Our ref: NO/2021/113750/03-L01
Your ref: 3/2021/0731
Date: 01 December 2021

REDEVELOPMENT OF THE EXISTING EDUCATIONAL FACILITY INCLUDING PART DEMOLITION OF THE EXISTING INFANT SCHOOL TO PROVIDE A STANDALONE NURSERY FACILITY, TOGETHER WITH THE REMODELLING OF, AND EXTENSION TO, THE EXISTING JUNIOR SCHOOL, AND ERECTION OF A NEW INFANT BLOCK TO THE REAR OF THE BUILDING, ALONGSIDE ADDITIONAL CAR PARKING. SOFT AND HARD LANDSCAPING TREATMENT AND VEHICULAR ACCESS WORKS OFF GREENACRE STREET. ST JAMES C OF E PRIMARY SCHOOL, GREENACRE STREET, CLITHEROE, BB7 1ED.

Environment Agency position

Figure 3 - Location of Infant Block and 2D Levels

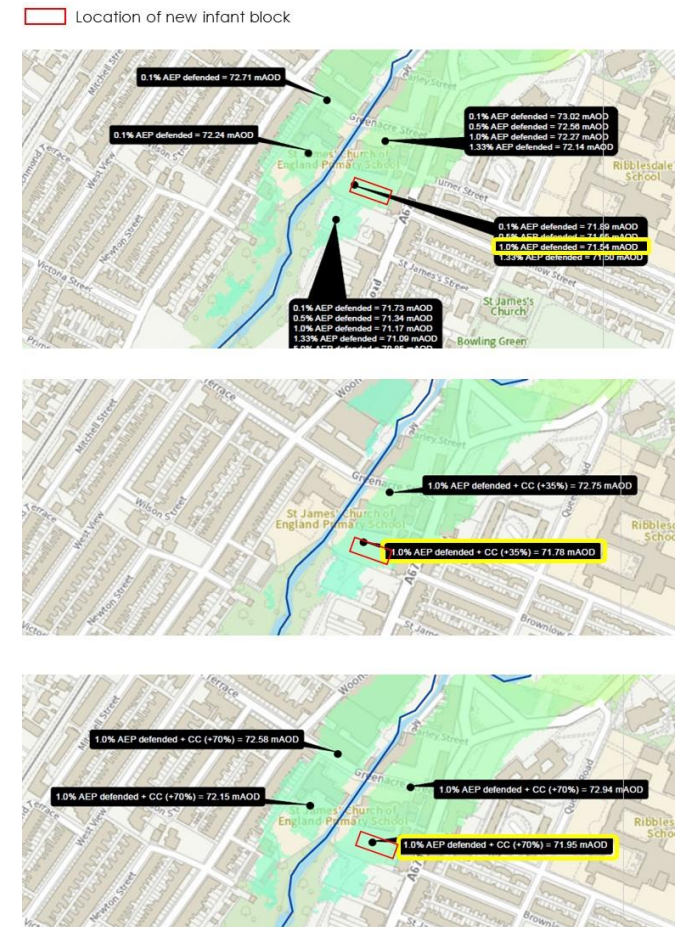
We note that further information has been uploaded to the LPA's planning portal and the receipt of an email dated 7 October 2021 from the applicant, has provided possible solutions to some of our concerns. The additional information also proposed that the new infant school would be raised above the on-site flood levels, this was to be achieved by using an open block/brick pier substructure.

Whilst the documentation provided shows that the amount of flood plain infill has reduced, it does not clearly demonstrate that the proposals will not increase the flood risk off site. The pier substructure will still reduce flood plain storage capacity and affect the flow of flood water around the new building. The substructure would also introduce the potential for blockage scenarios which could further affect the flow of flood water.

In order to overcome our objection in relation to the potential increase in flood risk offsite, the applicant would need to demonstrate that the arrangement underneath the proposed building would not obstruct the flow of flood water in the design flood (plus an allowance for climate change) and therefore inadvertently increase the flood risk elsewhere. This could be demonstrated by the use of revised detailed modelling for the site, incorporating the proposed design for the new school building and any other structures within the flood extent.
